SPR EA1N and EA2 PROJECTS

DEADLINE 2 – COMMENTS ON EXQ1 RESPONSES – 1.4 CONSTRUCTION

Interested Party: SASES

Issue: 4

TITLE
LINK 4b (B1122 - LEISTON ROAD)
MITIGATION MEASURES

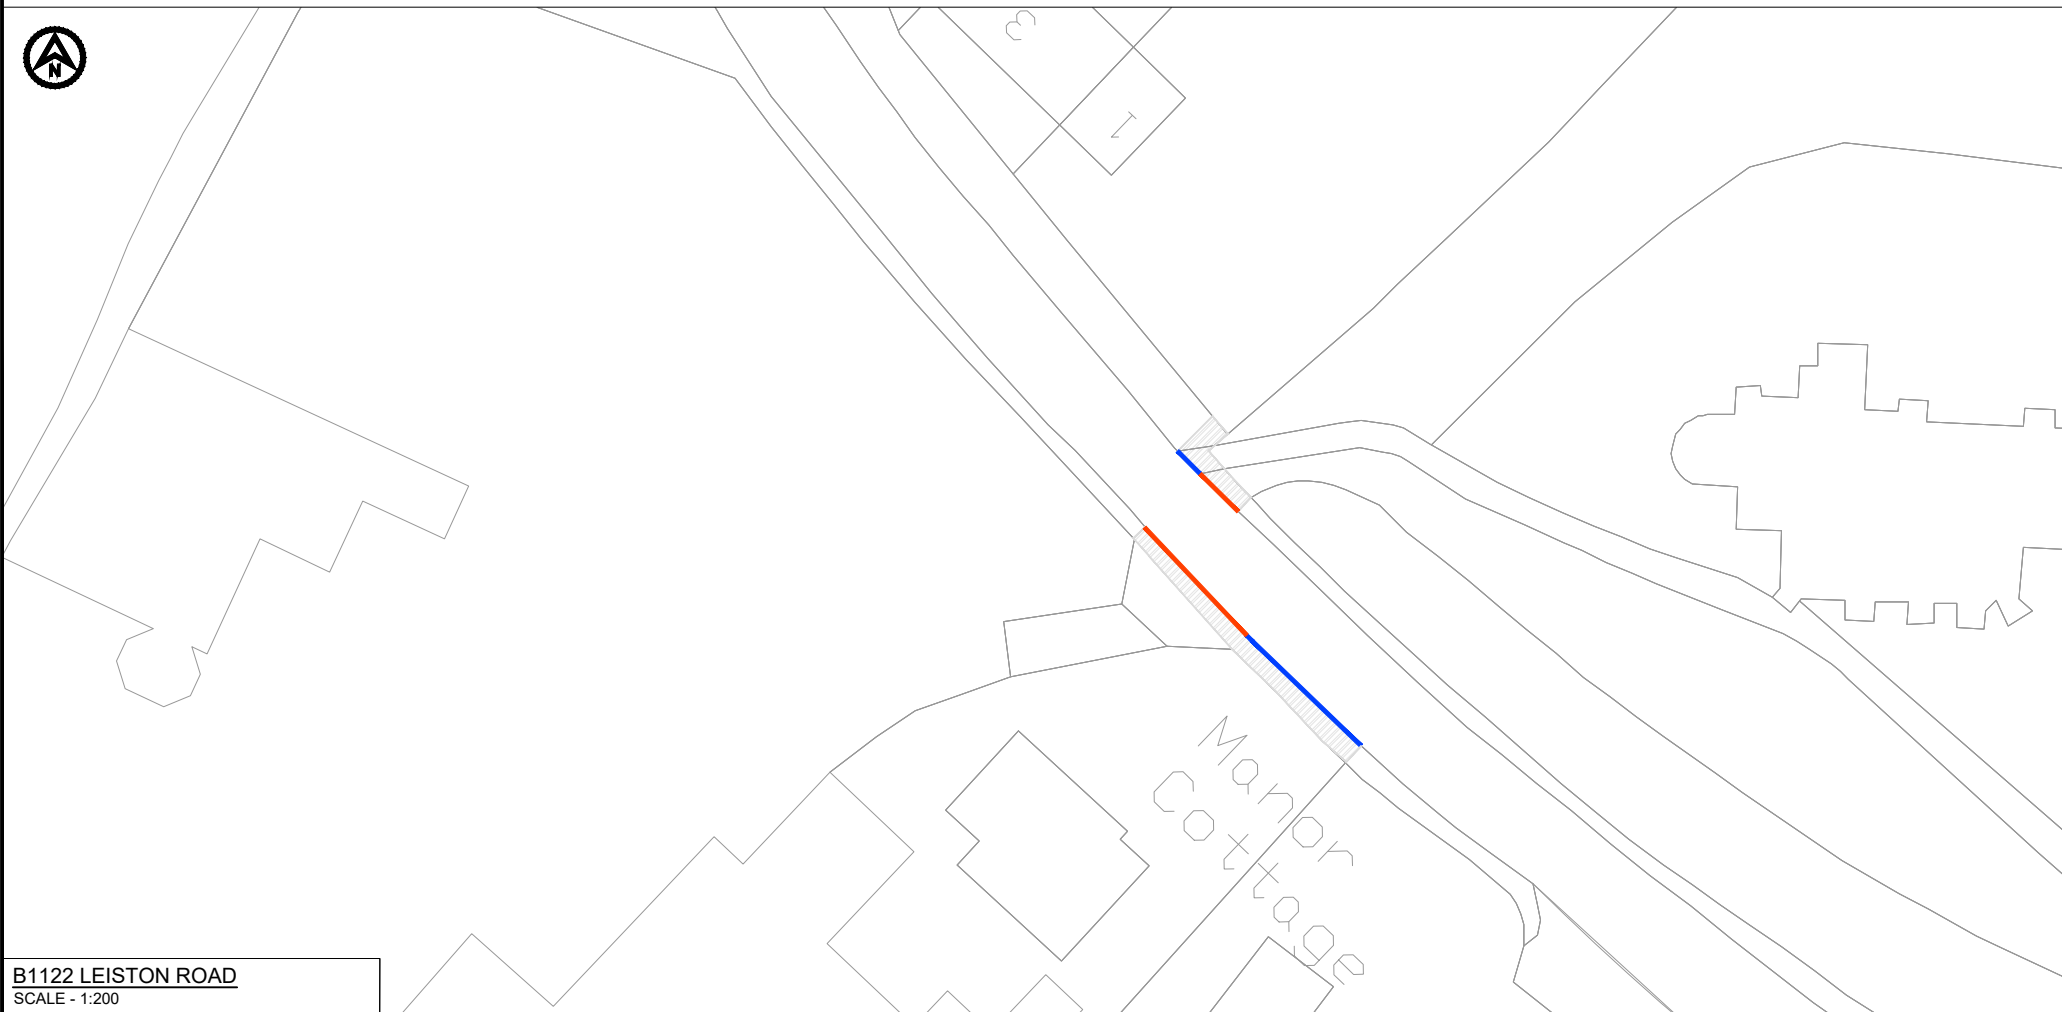
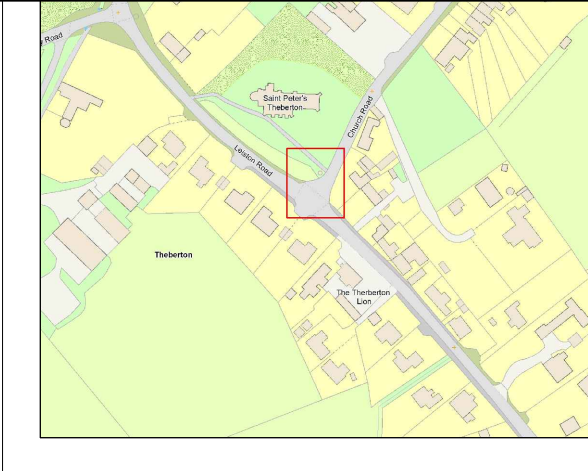
| | <p>at all times</p> | <p>about the extent of road closures and diversions likely to be caused by cable trenching, the Applicant is requested to respond to these points, and comment on the possible use of HDD to mitigate this particular construction effect. Can HDD be used to further limit the extent of diversions due to road crossings?</p> | <p>roads being fully closed to install the Projects' cables under the public highway. The Applicant will therefore ensure that the B1122 Aldeburgh Road will remain open at all times and minimise disruption by implementing the following measures (if required):</p> <ul style="list-style-type: none"> • The road crossings will be completed in two stages maintaining one traffic lane in each direction; • Traffic will be controlled through temporary traffic signals; • A safe route will be maintained for pedestrians through the works area along the B1122. • The Applicant will consult with the relevant highway authority and local stakeholders to develop a final Travel Plan as part of the discharge of requirements process. This will accord with the Outline Travel Plan (APP-588) in line with Requirement 28 of the draft DCO. • Advanced signing will be implemented to assist drivers in finding alternative routes; and • The works will be staggered (i.e. not closing a lane on the B1122 at the same time as the B1069). The Applicants note that the onshore cable route does not cross Sizewell Gap and therefore this road will not be affected as a result of trenching works. As per their response to question 1.2.66, the Applicants consider that there is insufficient lateral space to accommodate a | <p>1 submission : 'Applicants' Responses to Examining Authority's Written Questions Appendix 7 Onshore Crossing)' with regard to ensuring that the B1122 Aldeburgh Road would remain open at all times and that a safe route would be maintained for pedestrians through the works area along the B1122.</p> |

| 1.4.24 | B1122 and B1143 crossings open | With reference to oral submissions at OFHs 1 – 3 (7 – 9 October) raising concerns | Within Table 26.4, Chapter 26 Traffic and Transport of the ES (APP-074), the Applicant has committed to no | SASES welcomes the Applicant’s confirmation and commitments here (and reiterated in its Deadline |

| | | | trenchless crossing methodology at the B1122 crossing | |
